**Subject:** McPhillamys Gold Mine Project (SSD 9505) - Notice of Exhibition

Having reviewed the EIS, it is noted that dangerous goods (DG) storage quantities and transportation rates exceed the relevant thresholds in the Department's *Applying SEPP 33*. As such, the SSD is considered potentially hazardous under SEPP 33, and a preliminary hazard analysis (PHA) is submitted (EIS Appendix R) as required under SEPP 33.

TITLE			SCALE		DRAWING NO		REV	
McPHILLAMYS PROCESS PLANT OVERALL SITE PLAN			1:12,500		17016-00-G-001		2

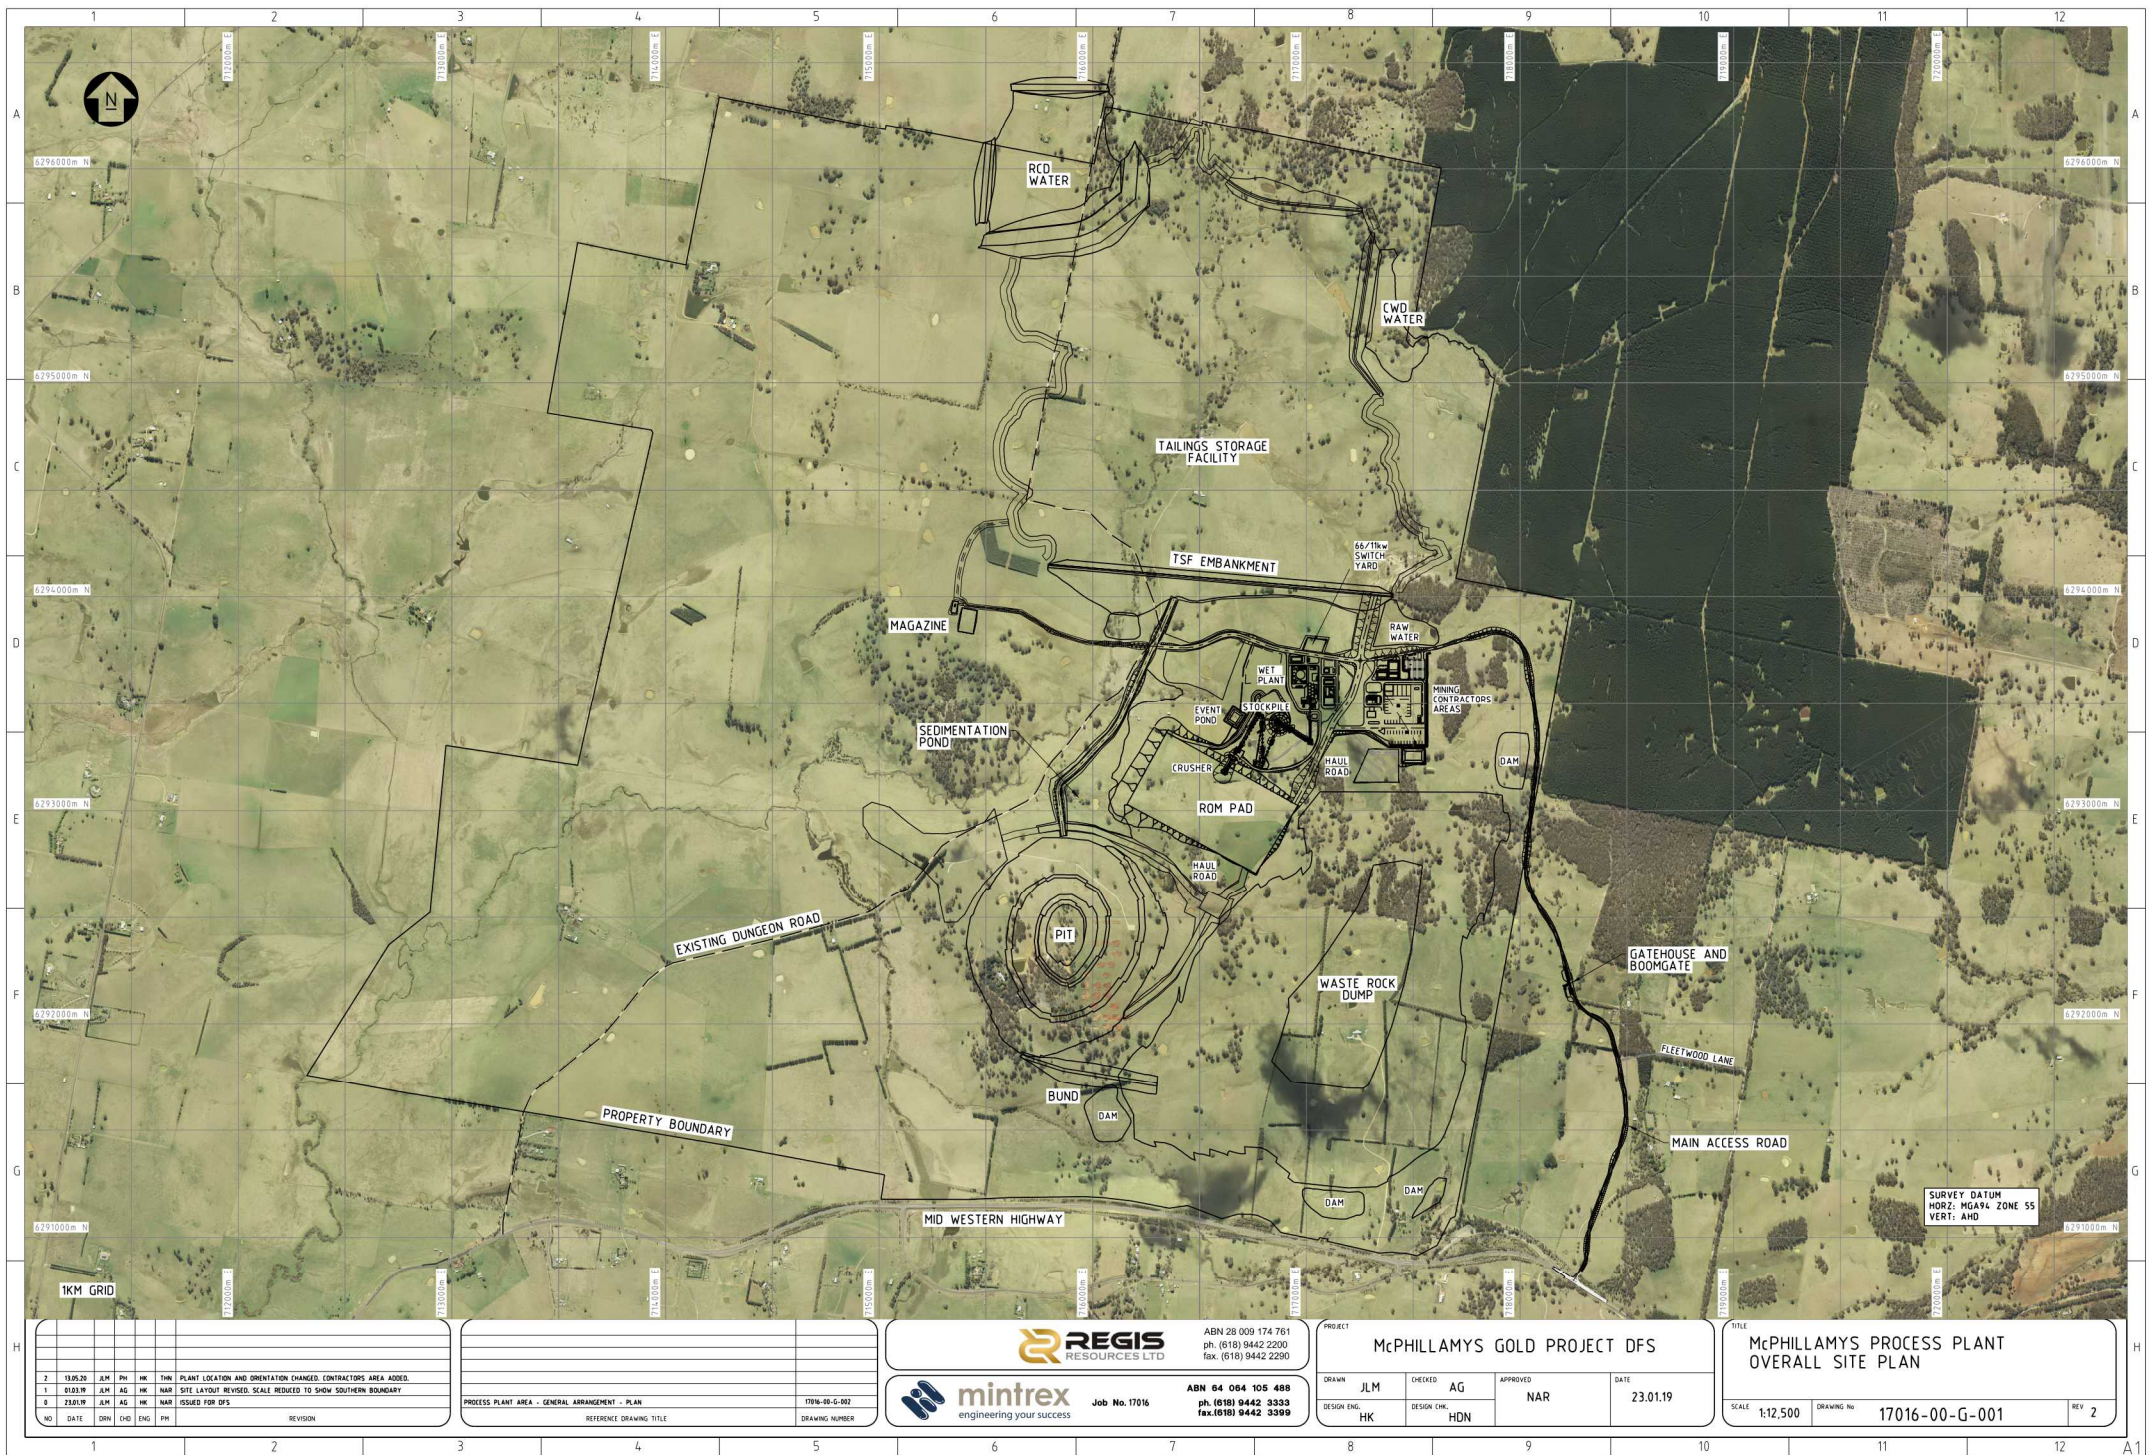
1. Provide a site layout diagram of the "magazine and ammonium nitrate emulsion storage" area as shown in EIS Figure 2.8, clearly showing:
    - a. the location of each magazine and tank;

- b. the quantity of dangerous goods (DG) within each magazine and tank;
    - c. separation distances between magazines, tanks and protected works as defined under AS 2187 and AIESG codes of practice; and

- d. how item 1c above can comply with all relevant Australian Standards and codes of practices for explosives and explosives precursors.
  2. In view of item 1 above, provide:

4. Provide a site layout diagram of the processing plant area as shown in EIS Figure 2.8, clearly showing:
  - a. the location of all DG and hazardous chemicals (which may be non-DG, such as diesel) stores and tanks. "Reagents store", "reagent area" and "emergency stockpile area" are noted;

- b. the quantity of DG and hazardous chemicals within each store and tank;
  - c. the separation distances between stores, tanks and protected works as defined under the relevant Australian Standards and consistent with relevant codes of practice; and

- d. how item 4c above can comply with all relevant Australian Standards and relevant codes of practice.
5. In view of item 4 above, and considering separation distances between 14 tonnes of LPG and 240 tonnes of diesel (only quantities and not locations are indicated in PHA Table 2, and Sections 4.3.1 and 4.3.2.3), provide verification that the fire impacts as shown in PHA Figure 6 would not escalate beyond the worst cases described in PHA Sections 4.2.3.2 (hydrogen cyanide) and 4.3.2.3 (flammable materials).
